Comments for Planning Application 21/00322/FUL

Application Number: 21/00322/FUL

Address: 24 Rosamund Road Oxford OX2 8NU

Proposal: Alterations to roof to form hip to gable, formation of 1no. dormer to rear roofslope, insertion of 1no. rooflight and 3no. additional solar panels to front roofslope. Demolition of existing rear extension and erection of a single storey rear extension. Insertion of 1no. window to front elevation, removal of 1no. window and door to side elevation, alterations to fenestration and painting of existing render. Demolition of 2no. existing outbuildings and erection of a rear garden outbuilding.

Drawing No: **113-1120 - P02**

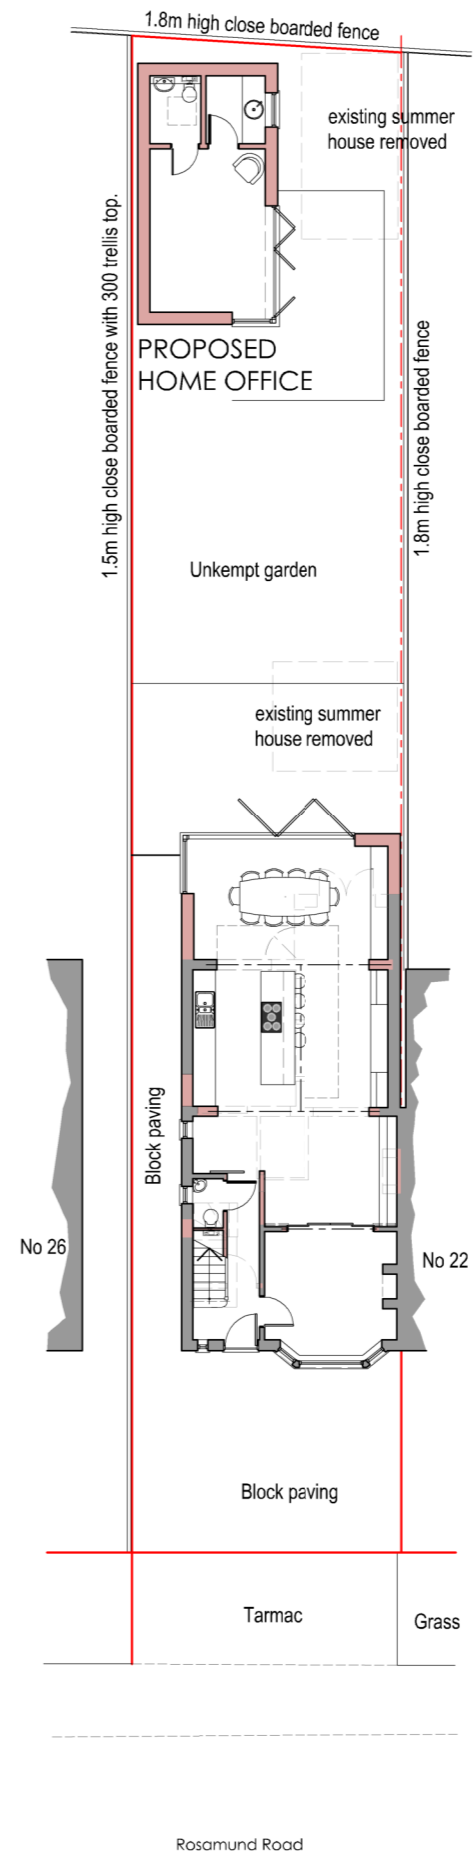
Comment: The elevation view and the positioning of the garden office on the plot plans do not agree.

The large window of the building on the elevation plan show that it faces west when, in fact, on the plot plans it shows it to be facing south.

The width of the garden should also be checked (it doesn't look wide enough on the plans) so it can accommodate the window/west facing orientation if that is the intentional siting.
